# CITY OF ALBUQUERQUE

July 6, 2007

**Re: Sawmill Village Conceptual Grading and Drainage Plan  
Engineer's Stamp dated 6-15-07, (H13/D25A)**

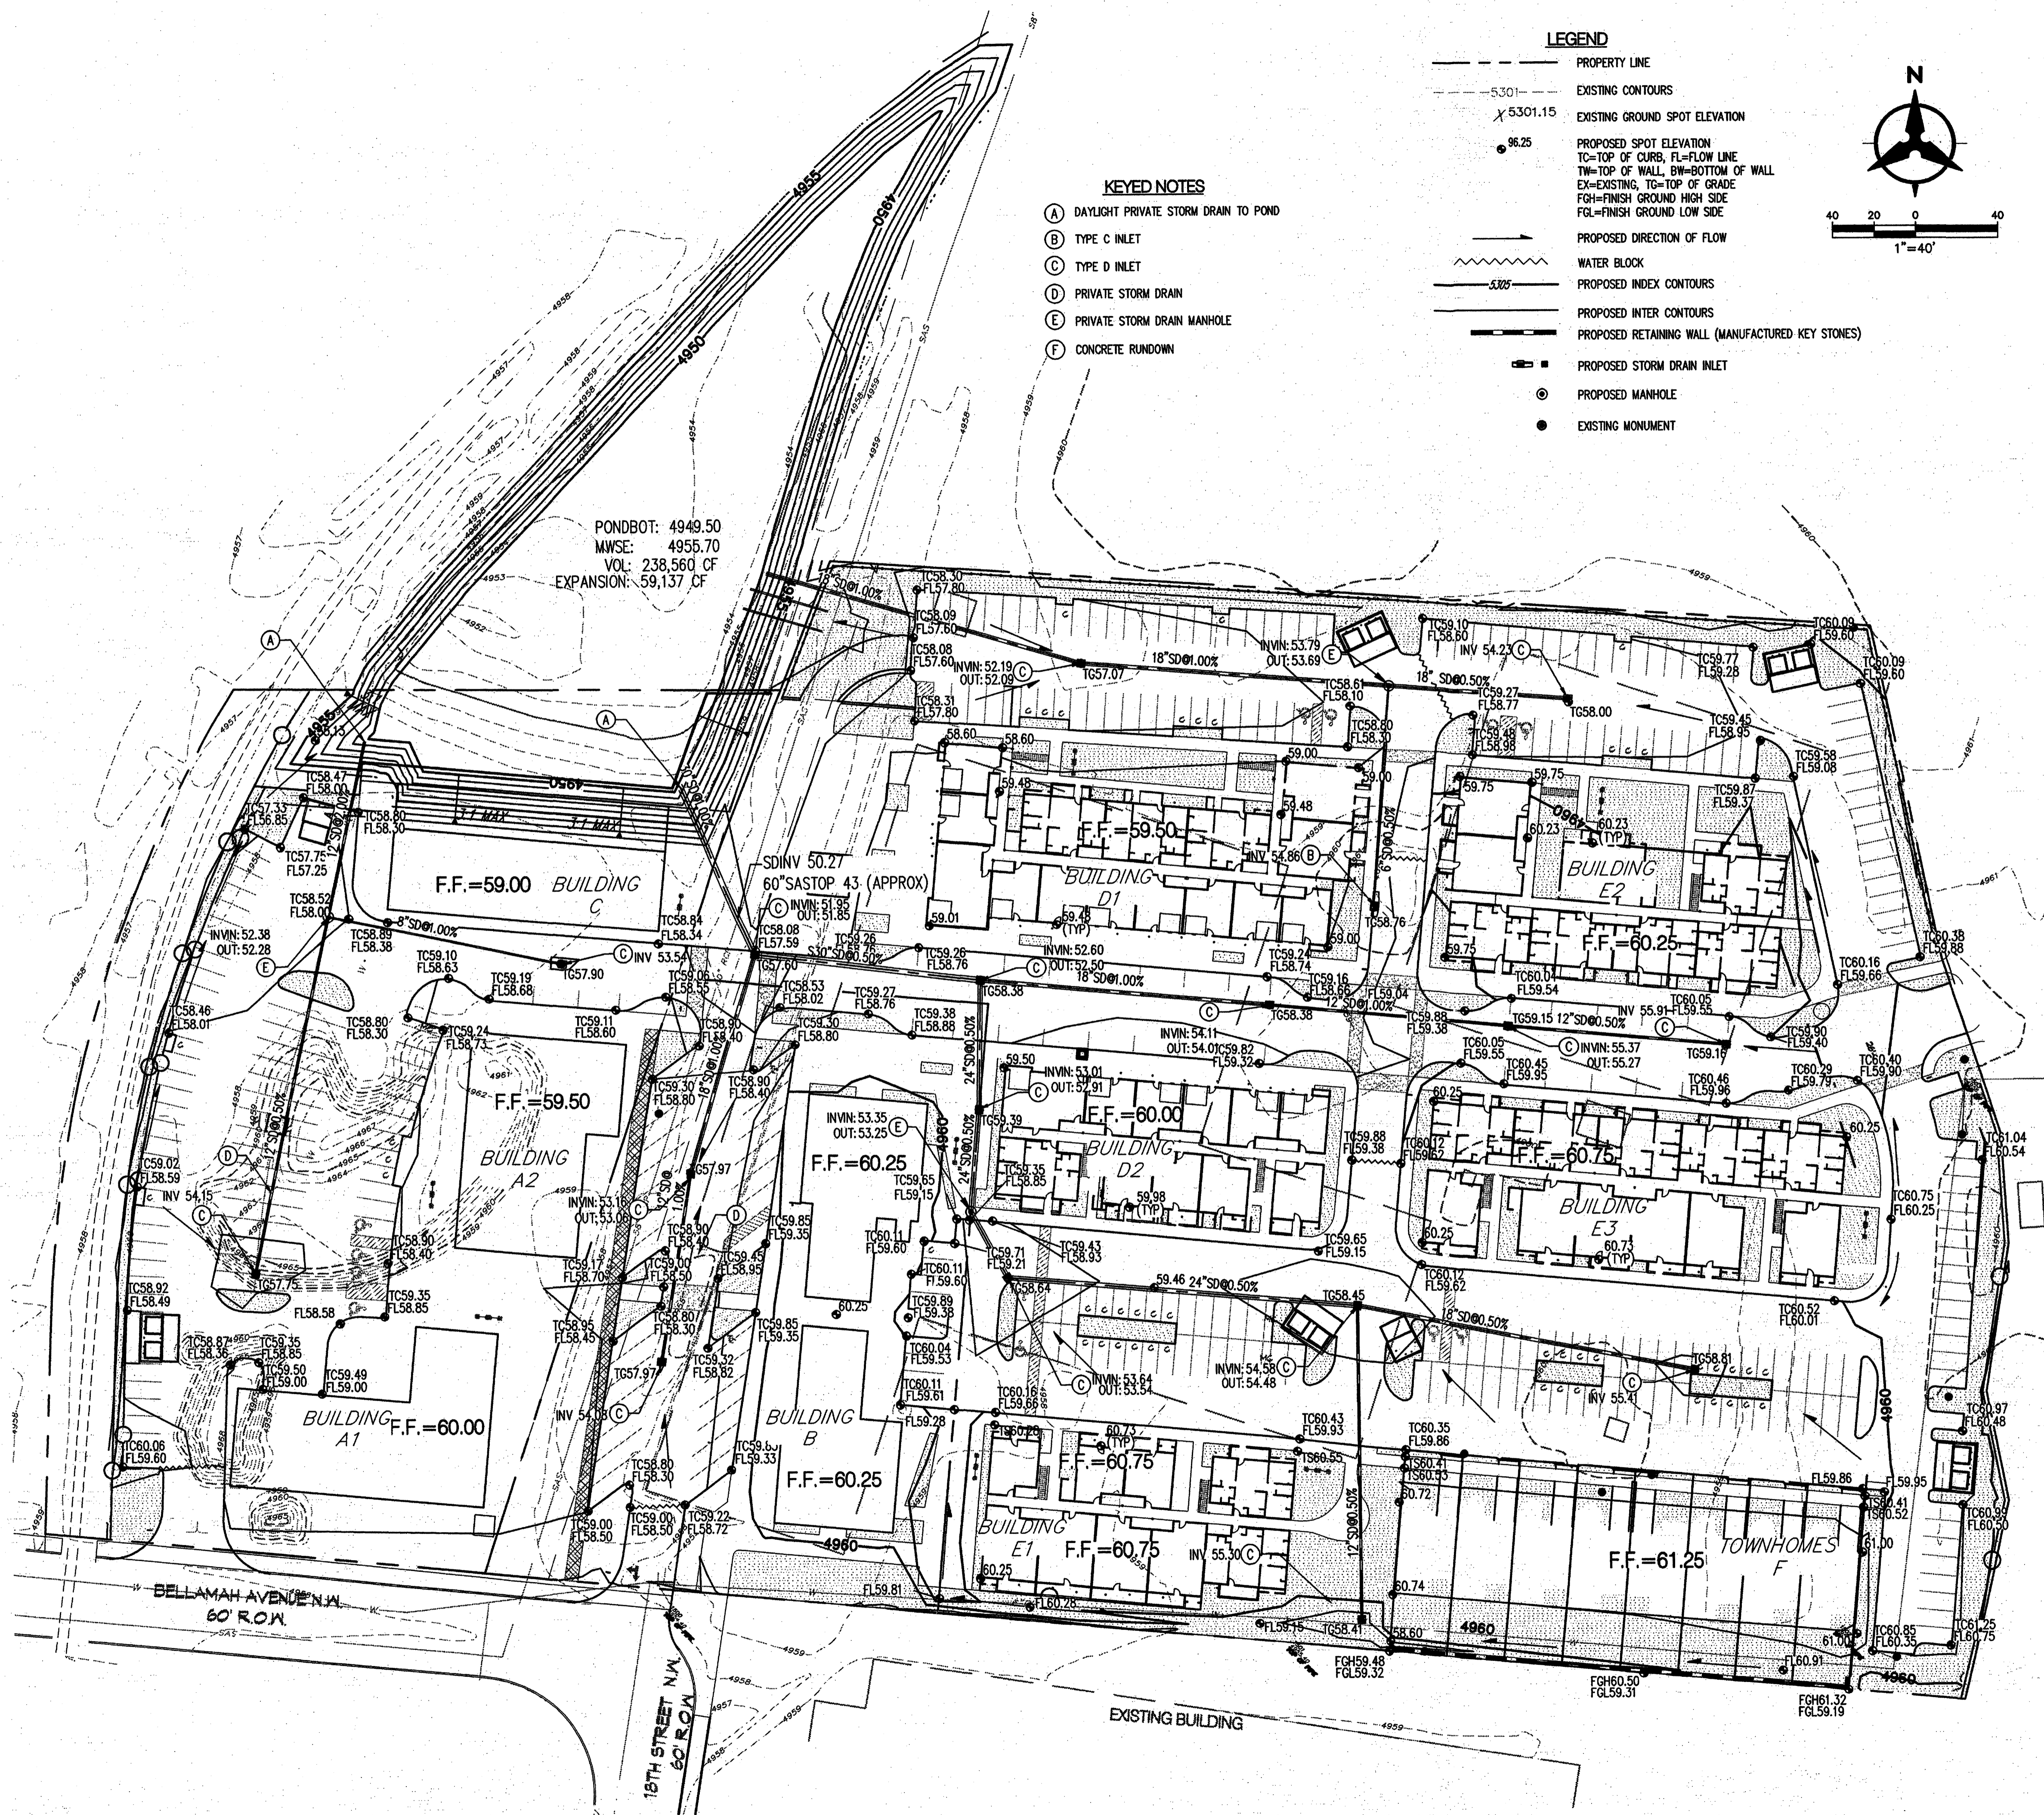
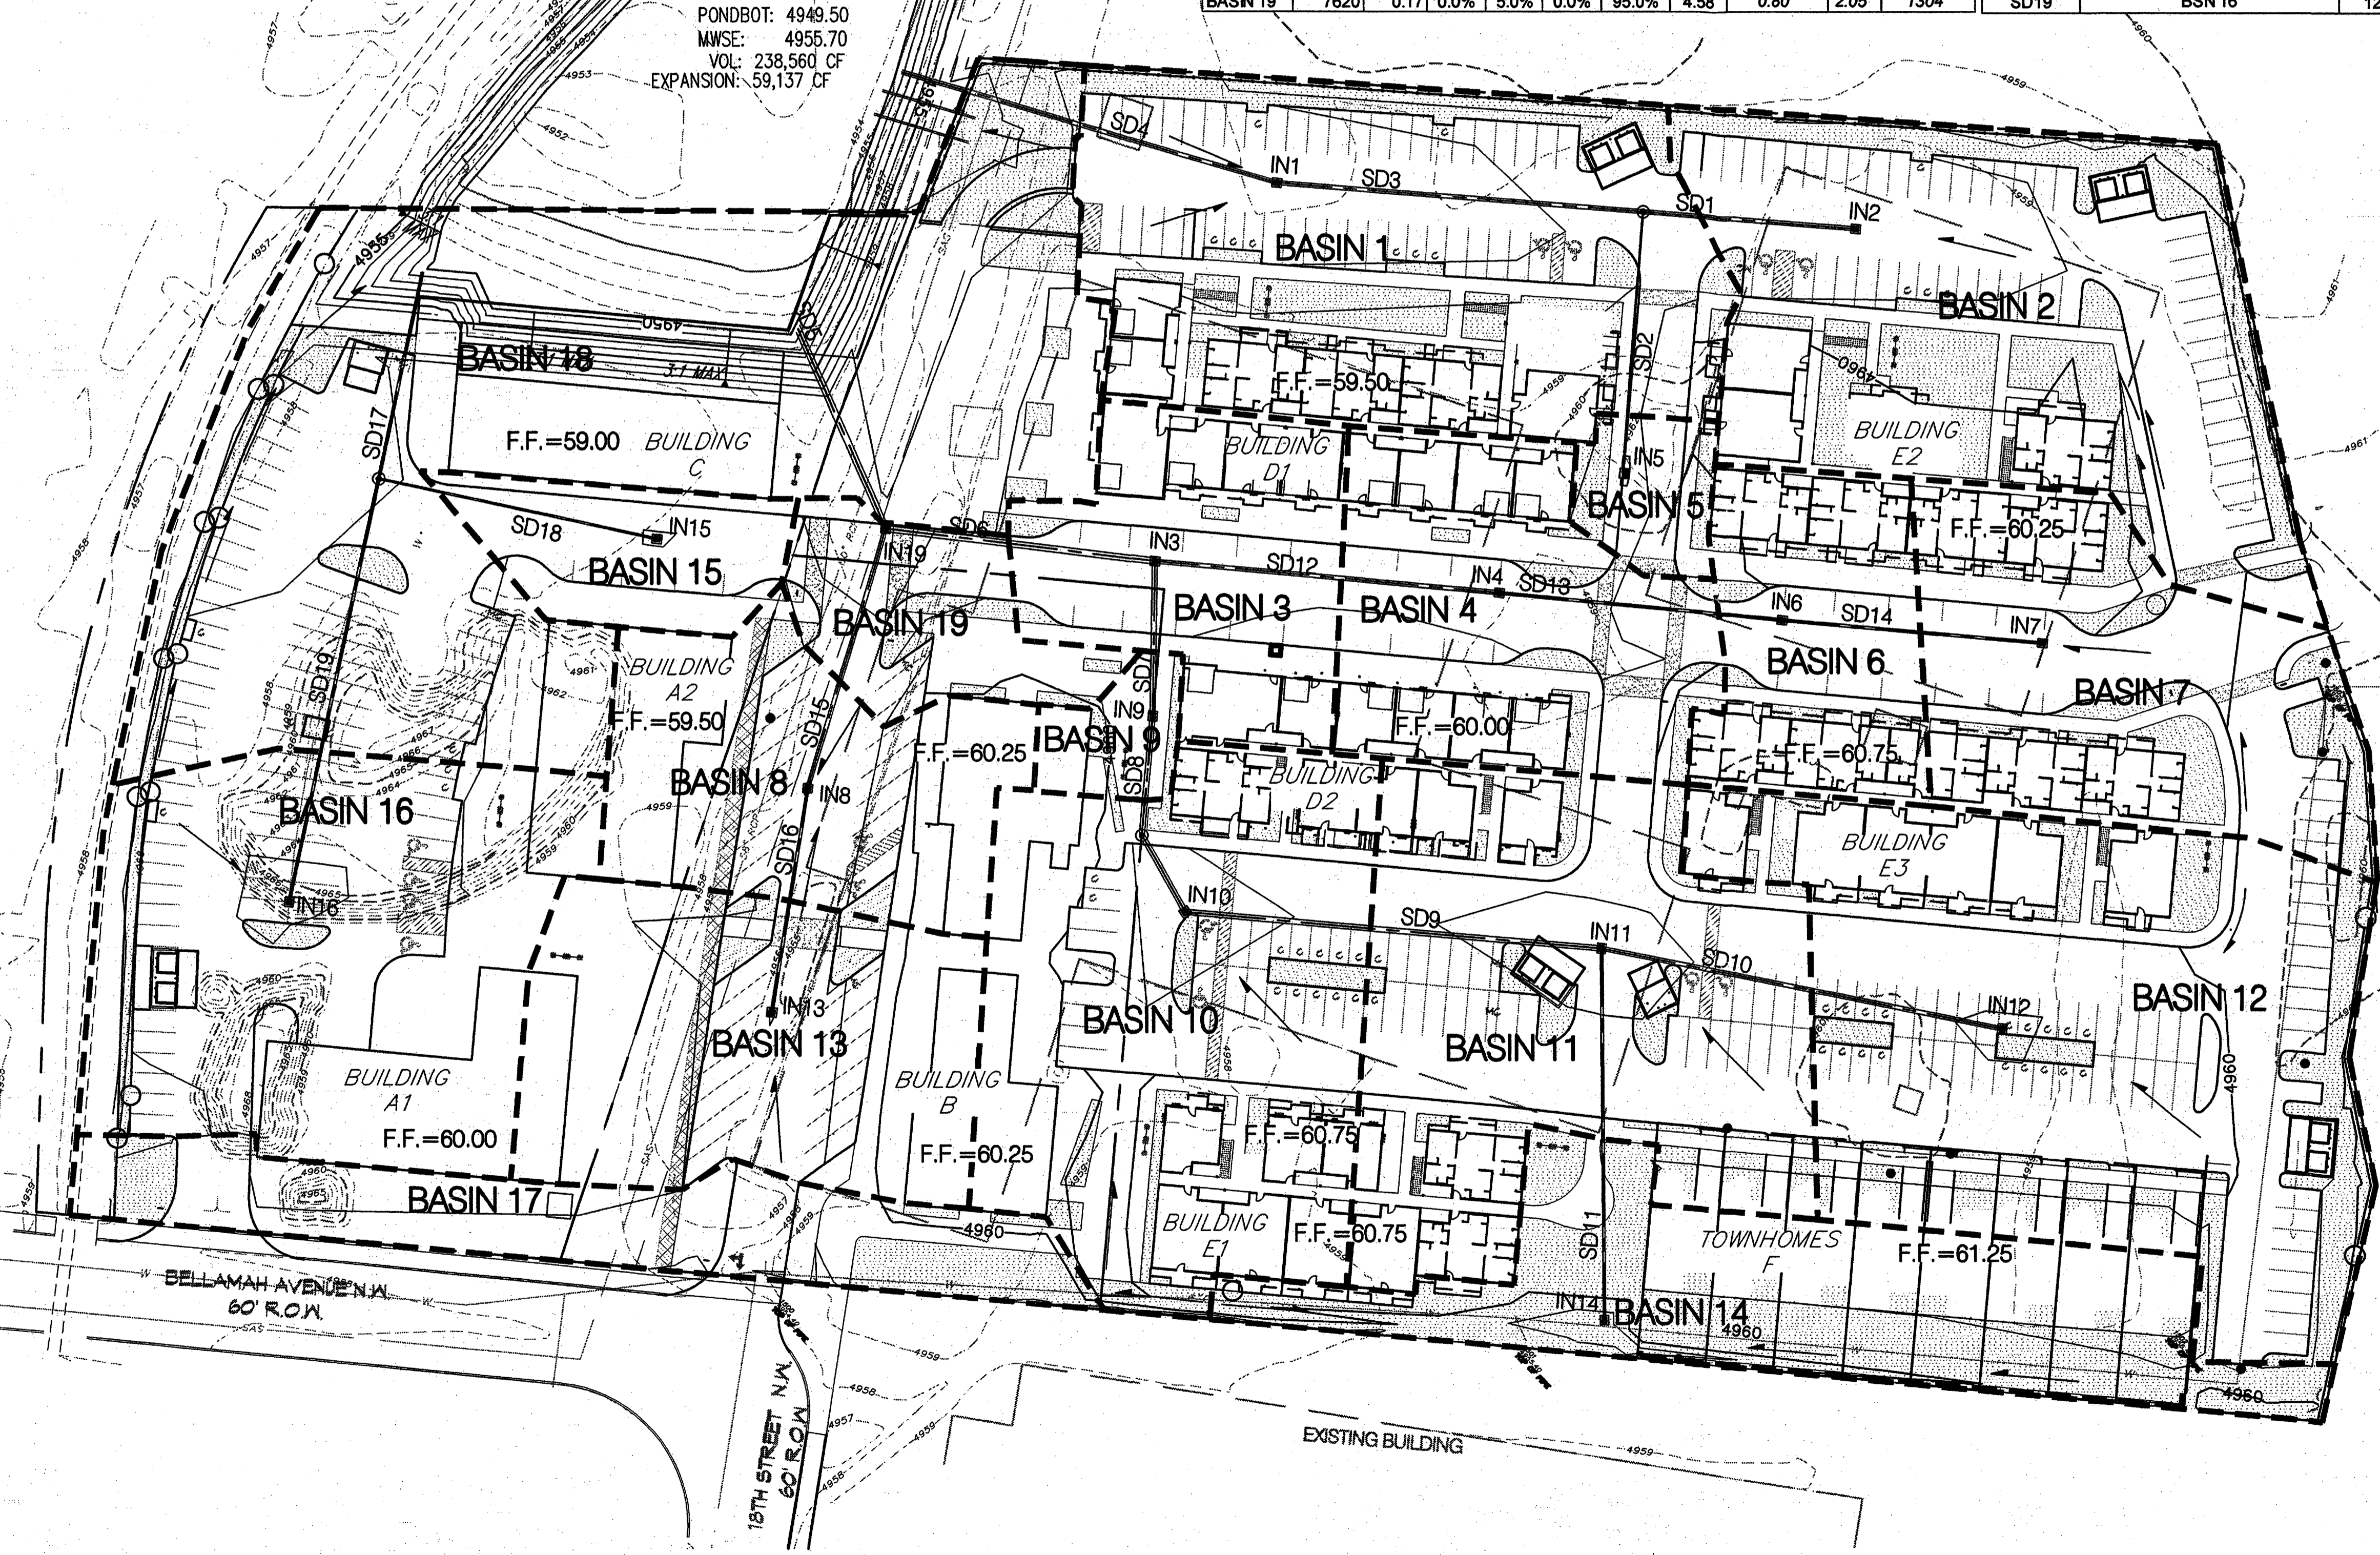
Prior to Building Permit approval, please show the dimensions of the new pond and the existing outfall pipe. An agreement and covenant will be required for the maintenance of the pond as well as the information sign. Also, please provide all applicable build note necessary to make this plan constructible.
